July 31, 2020

**RE: STONE AGE CLIMING GYM PERMIT NUMBER BP-2019-33977  
TRAFFIC CERTIFICATION FOR PERMANENT CERTIFICATE OF OCCUPANCY  
RESPONSES TO COMMENTS:**

1 | partial courtyard and proposed ramp plan
 1/4" = 1'-0"

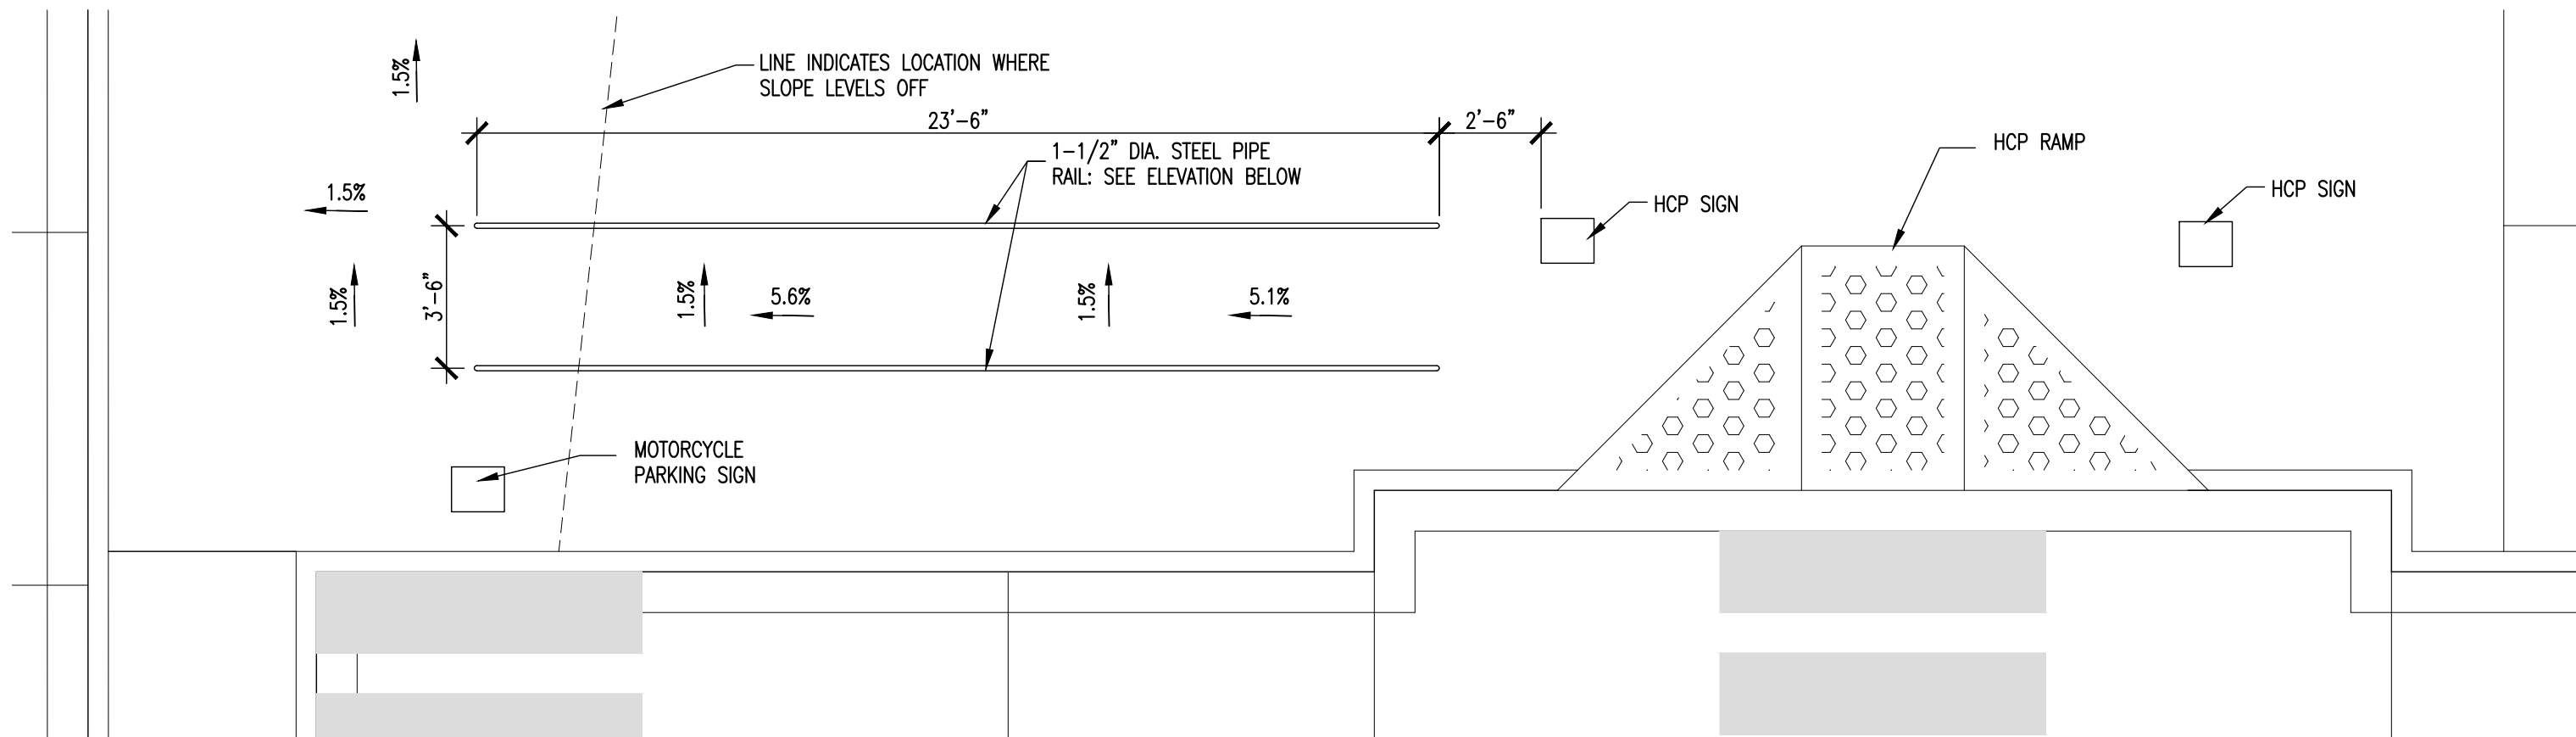
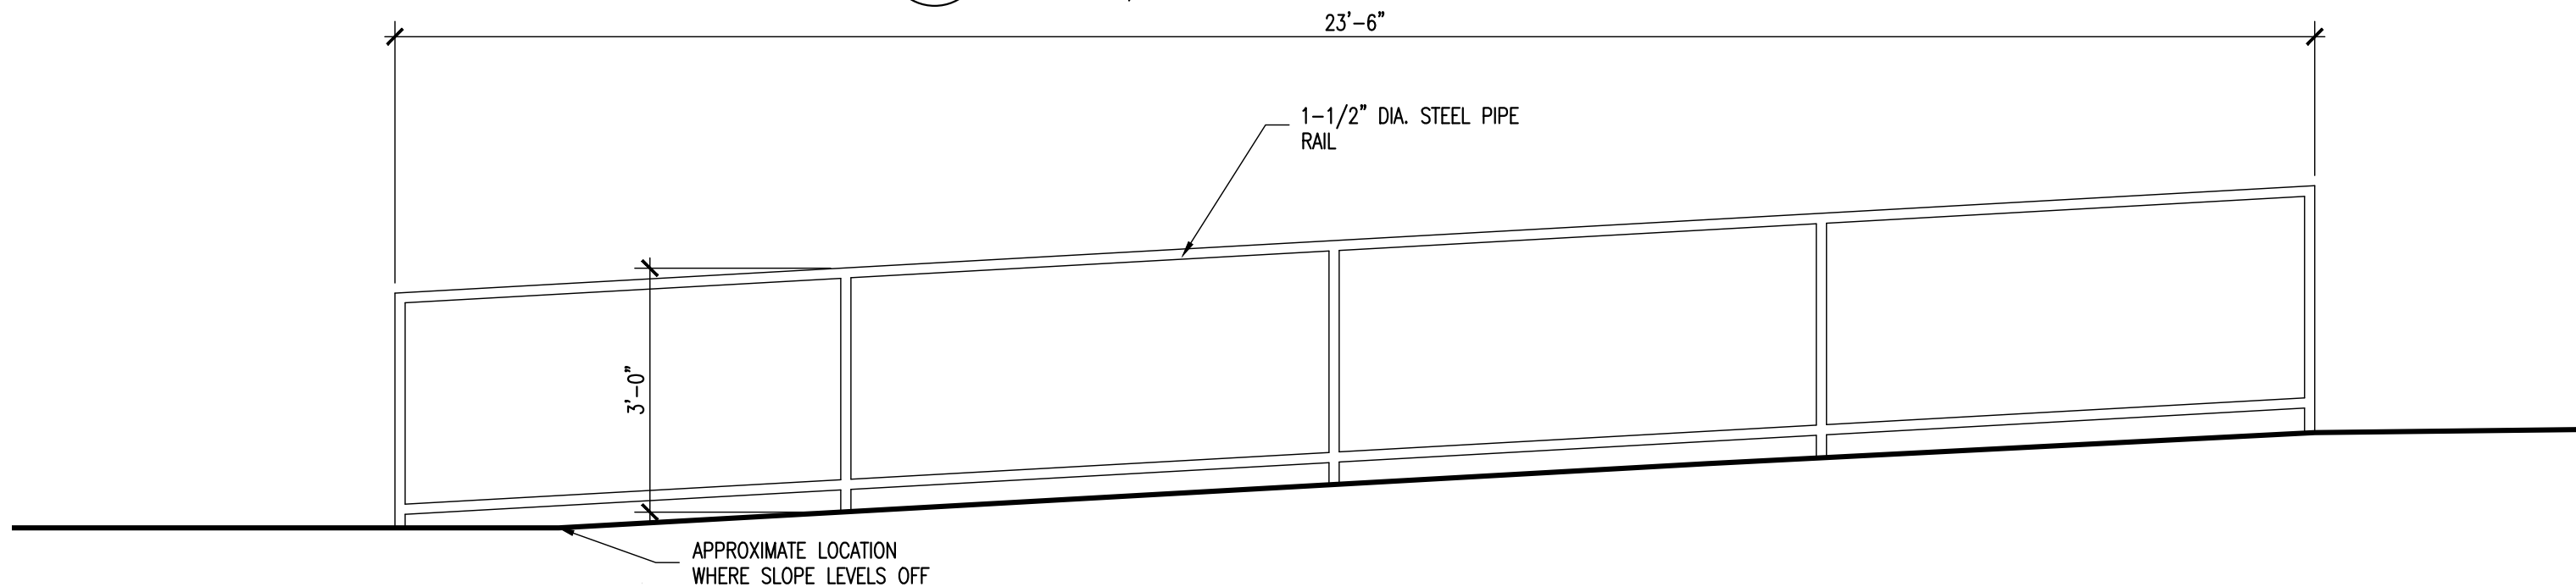
This letter is to acknowledge the comments given to us by Nilo Salgado, Ernie Gomez and Jeanne Wolfenbarger of the Transportation Department regarding the accessible path requirement between Stone Age Climbing Gym and Tin Can Alley. We are proposing a new ramp to be installed by means of two compliant handrails at a location adjacent to the Stone Age handicap parking stalls at a location which complies with slope requirement in all directions. Furthermore, we propose to provide a temporary barricade adjacent to the Stone Age handicap spaces that will direct disabled patrons to the Stone Age entrance only. This barricade would be removed once the permanent handrails are installed.
